# Comments for Planning Application 21/00347/VAR

Application Number: 21/00347/VAR

Address: 312A Woodstock Road Oxford OX2 7NR

Proposal: Variation of condition 7 (Details - Front Garden) of planning permission 20/02631/FUL (Demolition of existing bungalow. Erection of 2 x 4-bed dwellinghouses. Provision of bicycle and bin stores and associated landscaping.) to allow additional car parking.[cr]

PROJECT 312a Woodstock Road	
DRAWING Proposed Plans	
SCALE @ A1 1/100	SCALE @ A3 1/200
DRAWING No. 348 / P / 003	REVISION No. E

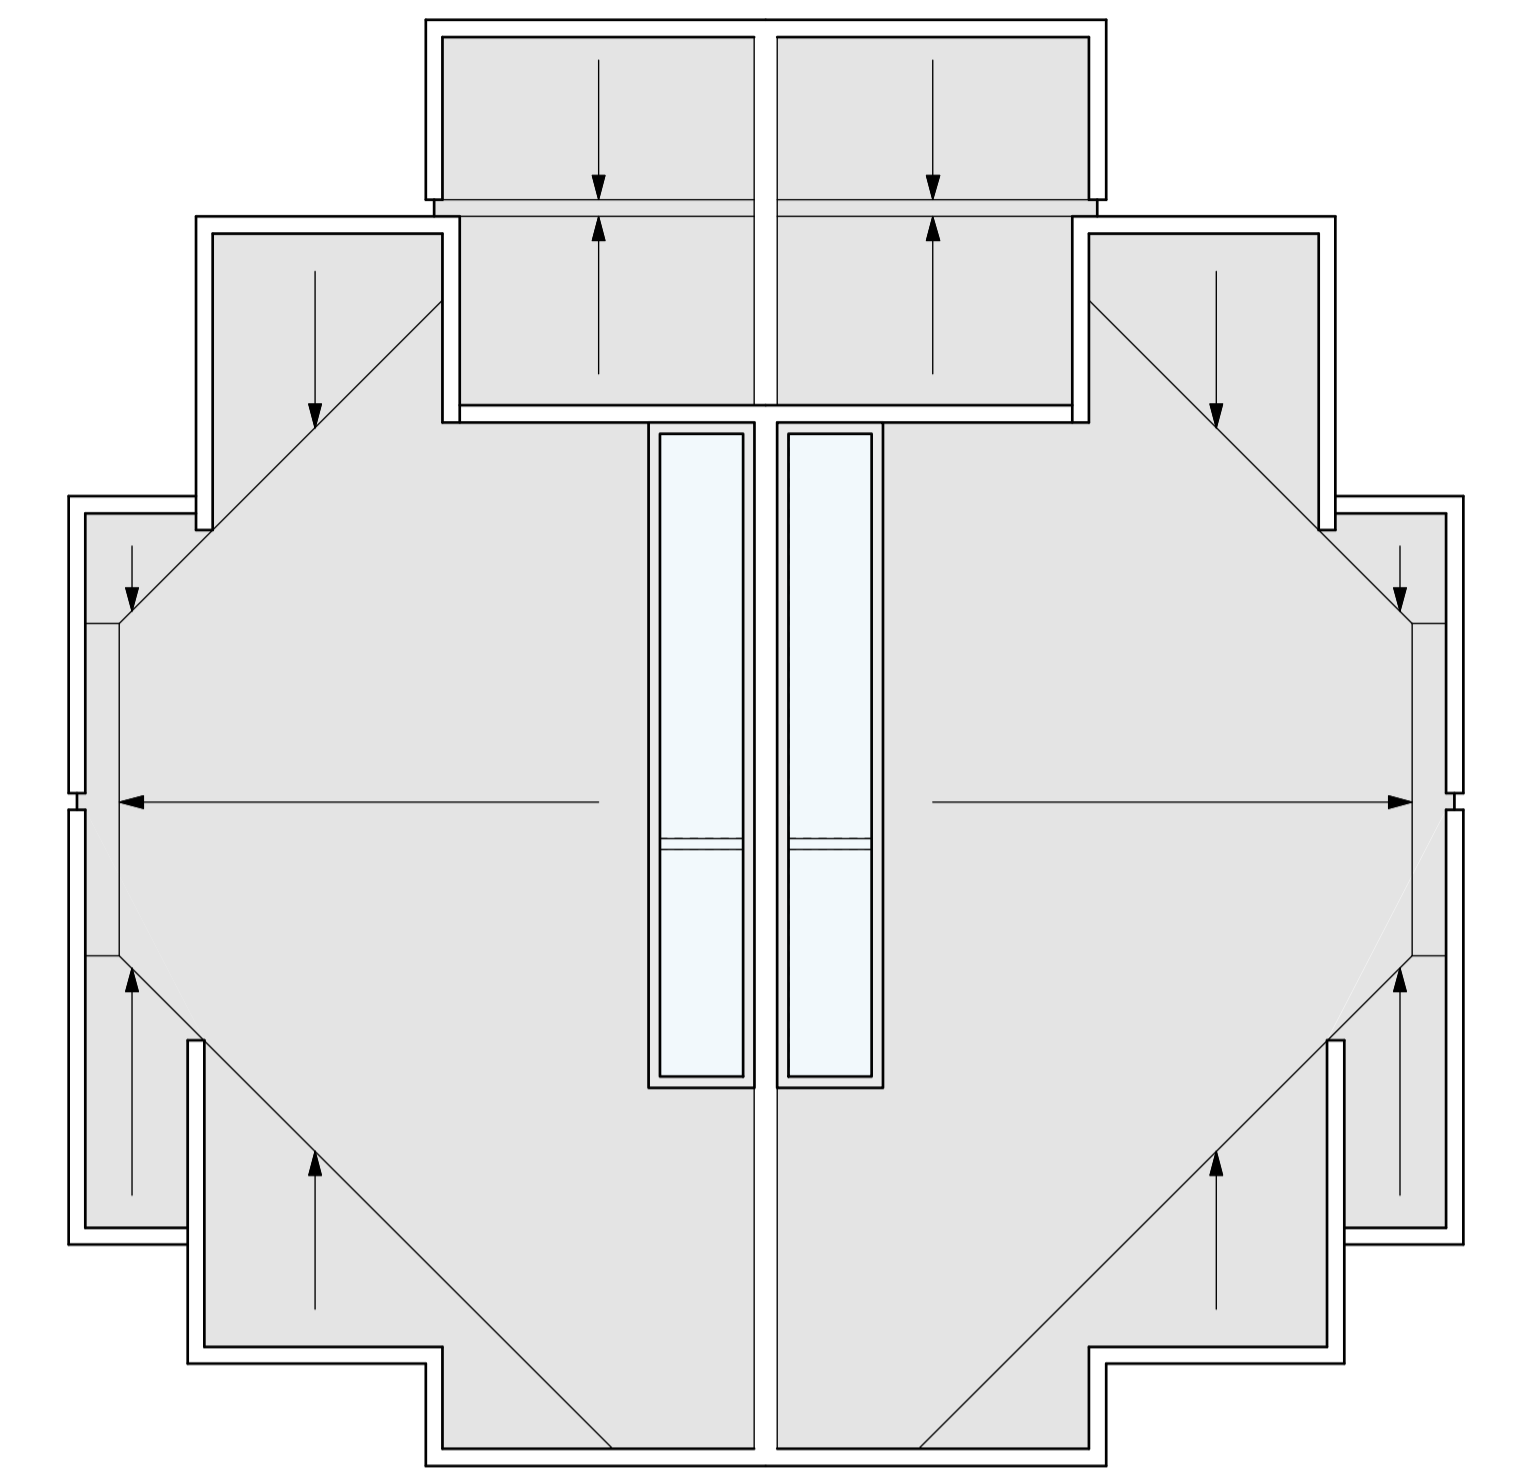
I note the developers of the site at 312A Woodstock Road have put in a request for an amendment to the planning approval for re-landscaping the front garden of House No 2. to include provision of a car parking space.

On the basis that planning permission was granted with parking provision (disabled or otherwise) for only House No. 1, I object to the proposed amendment for the inclusion of car parking to House No 2. I object to the proposed change and treatment to the front garden from that shown on the original plans which were granted planning approval, and which presumably met all considerations of importance and necessary requirements of the Planning Committee. This amendment to the planning application is unnecessary.
